Our Ref: FP/173/08/

Minor alteration to change roof detail over main entrance doors from hipped to gable detail & installation of new red fabric 4m square jumbrella

The Southdowns 133 Felpham Way Felpham

Thank you for your internet comments made on 29th September 2008 and recorded as follows:

Title
PROPOSED ELEVATIONS, ROOF
PLAN AND SITE PLANS

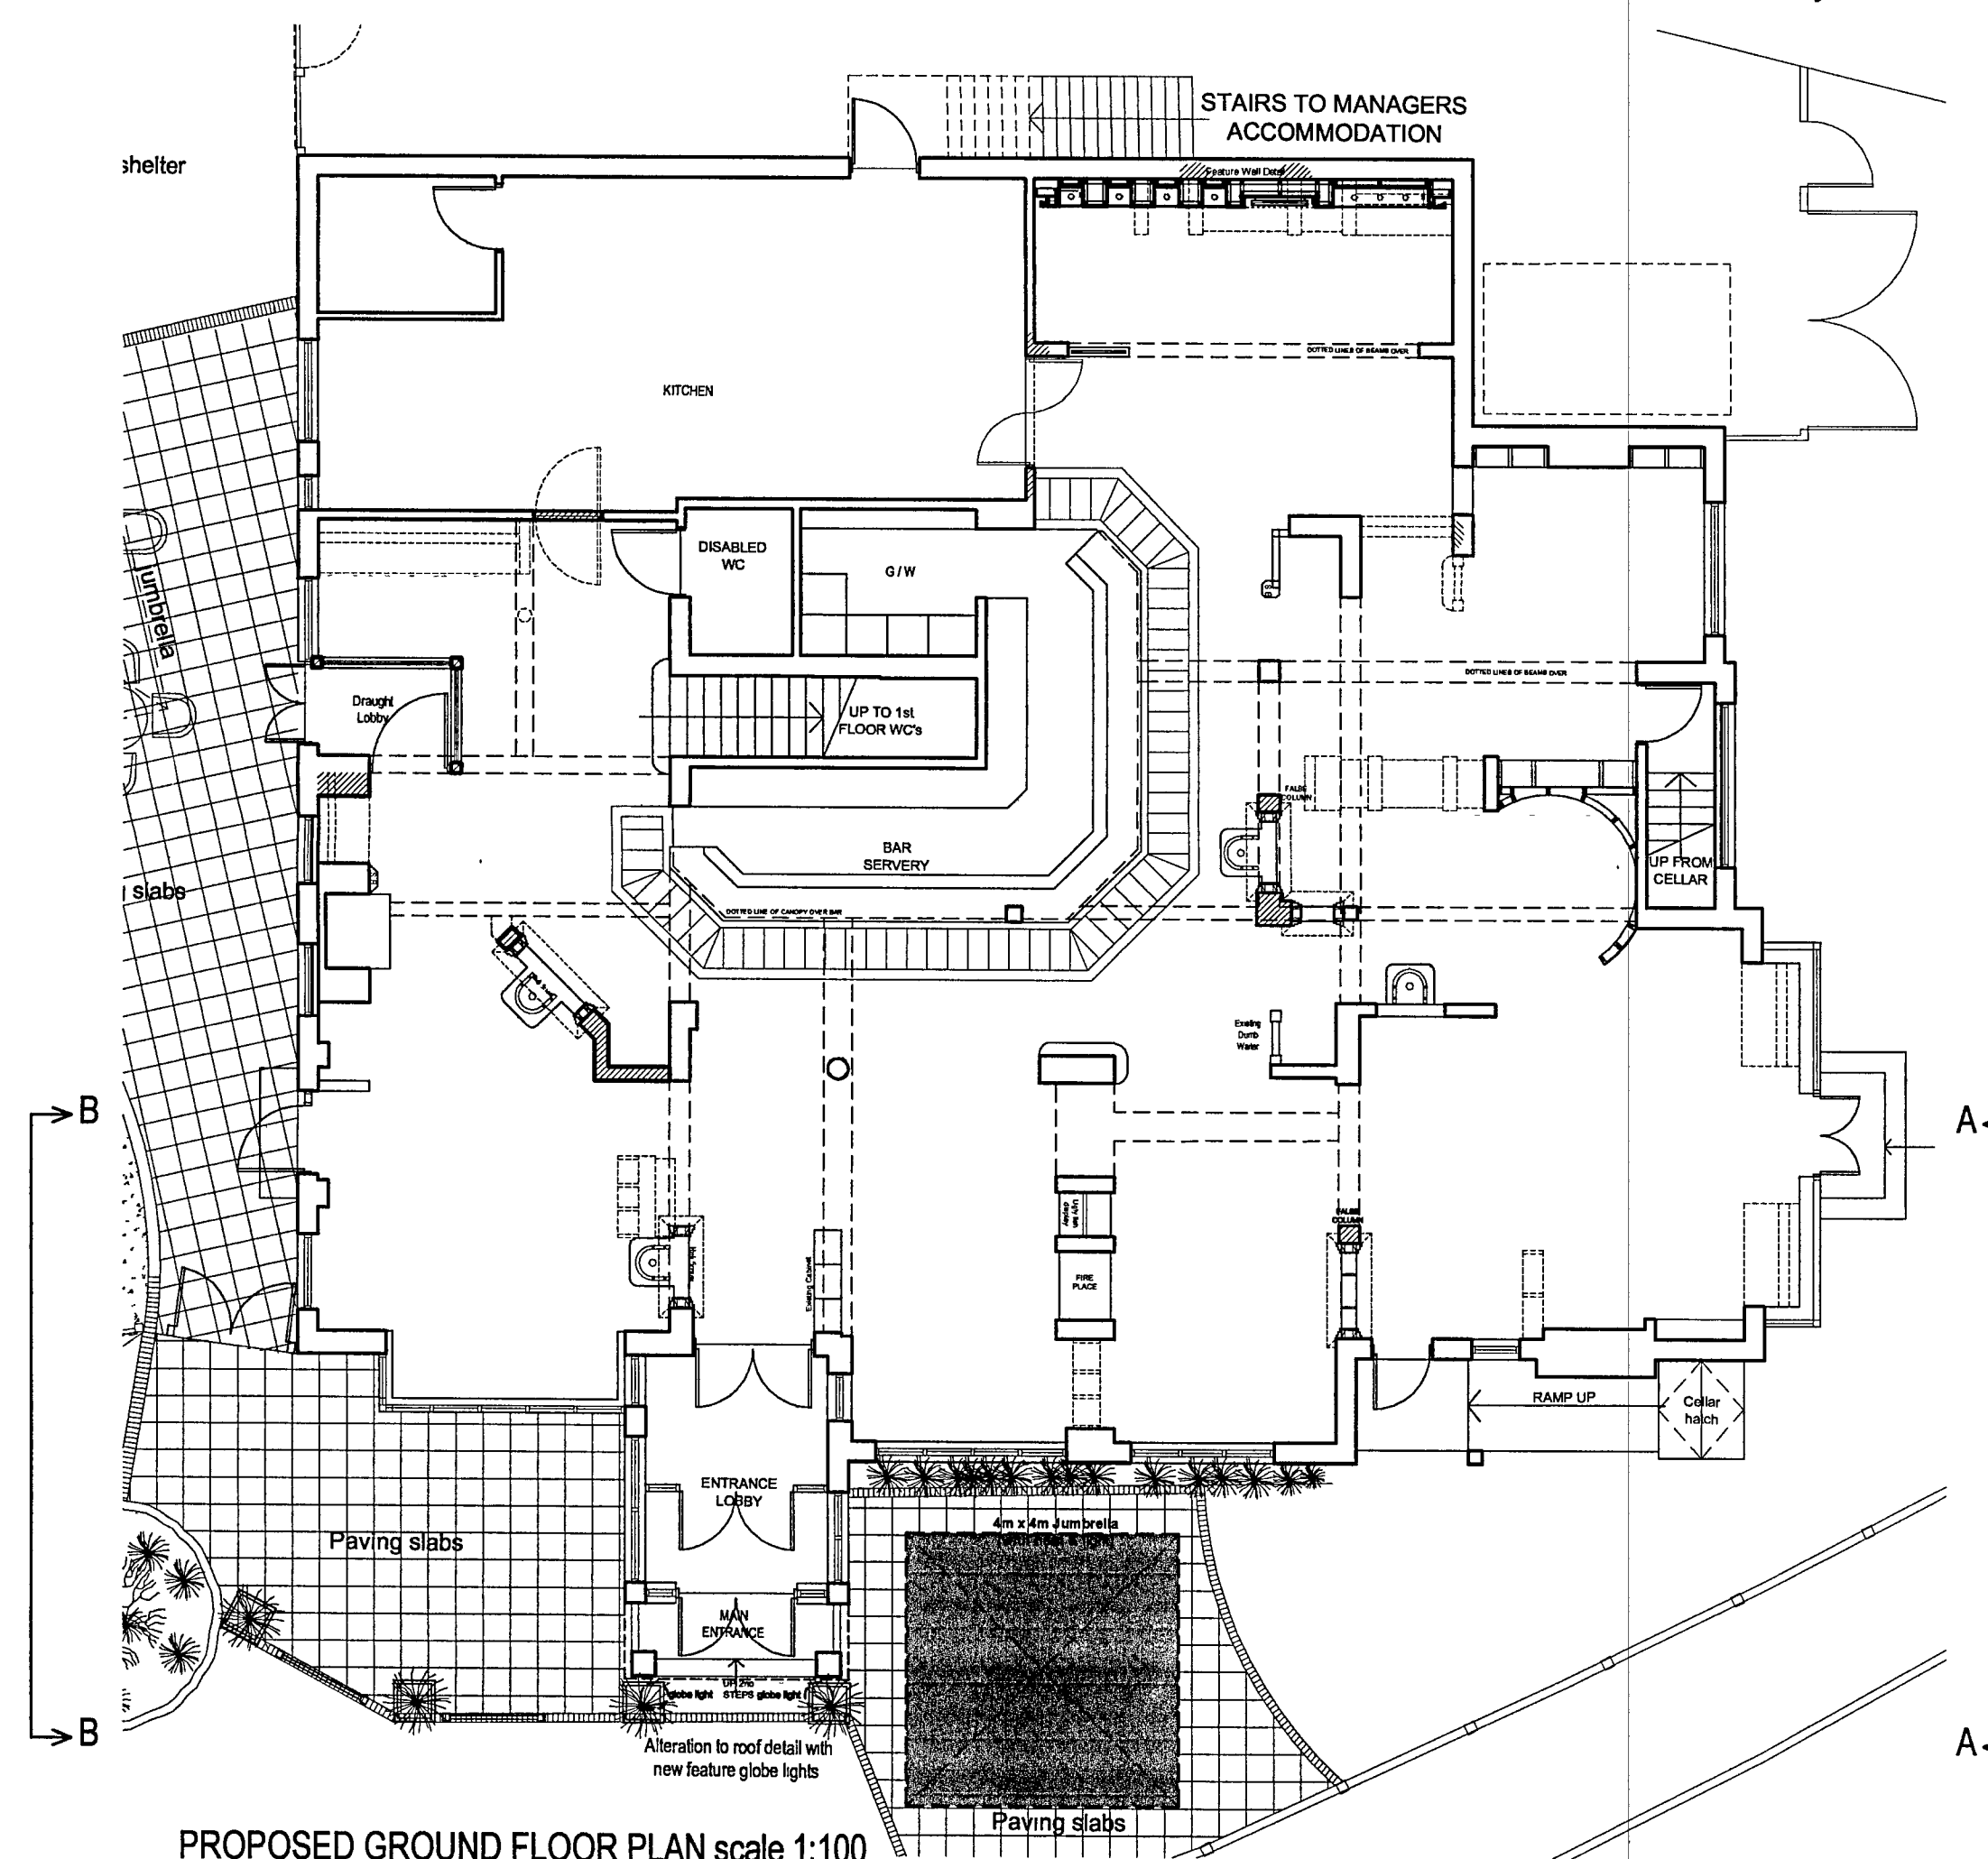
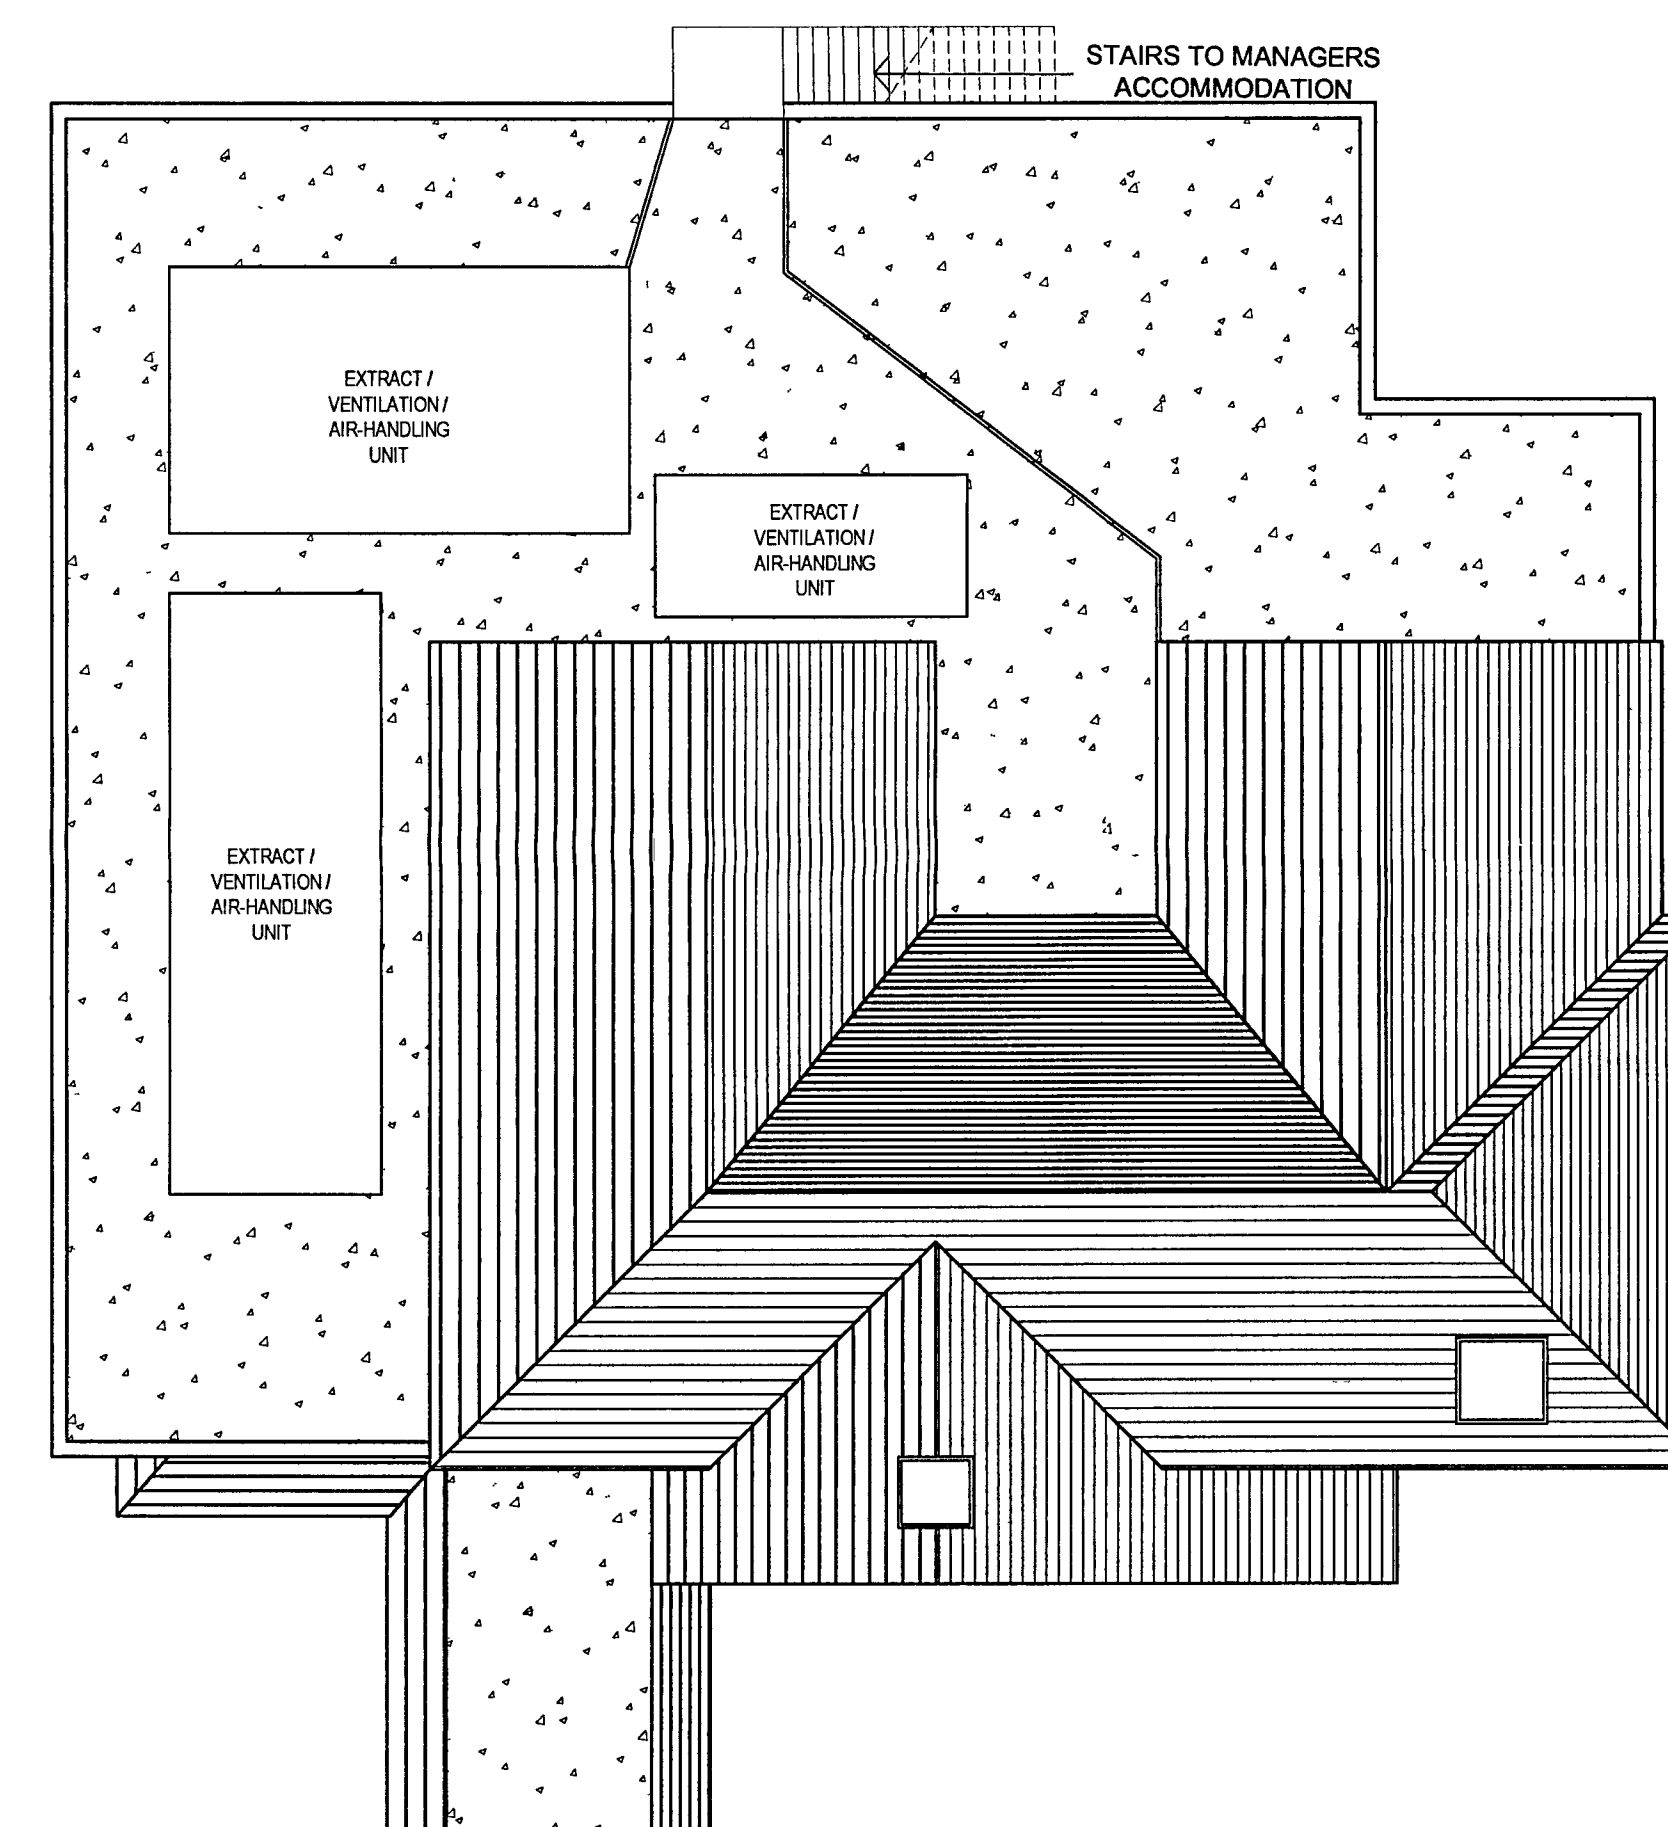
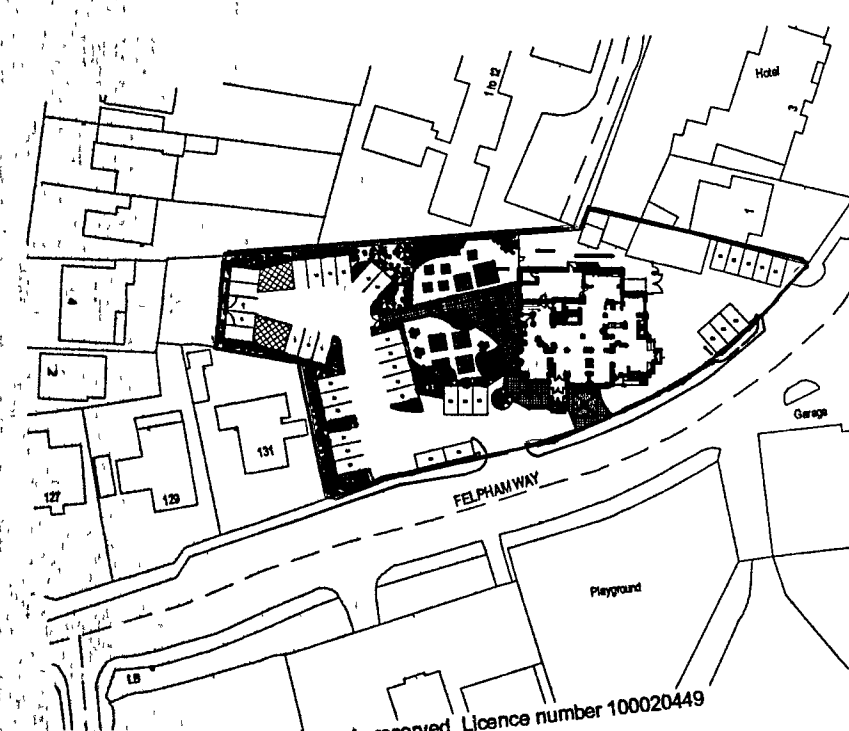
1. *The size and colour of the proposed Jumbrella will affect the visual amenity.*□
2. *The Jumbrella may be distracting to passing traffic where there is a Pelican crossing and a busy roundabout in the immediate vicinity causing a potential safety hazard to both pedestrians and motorists.*□
3. *The proposed site of the Jumbrella for external seating is not appropriate adjacent to such a busy road.*
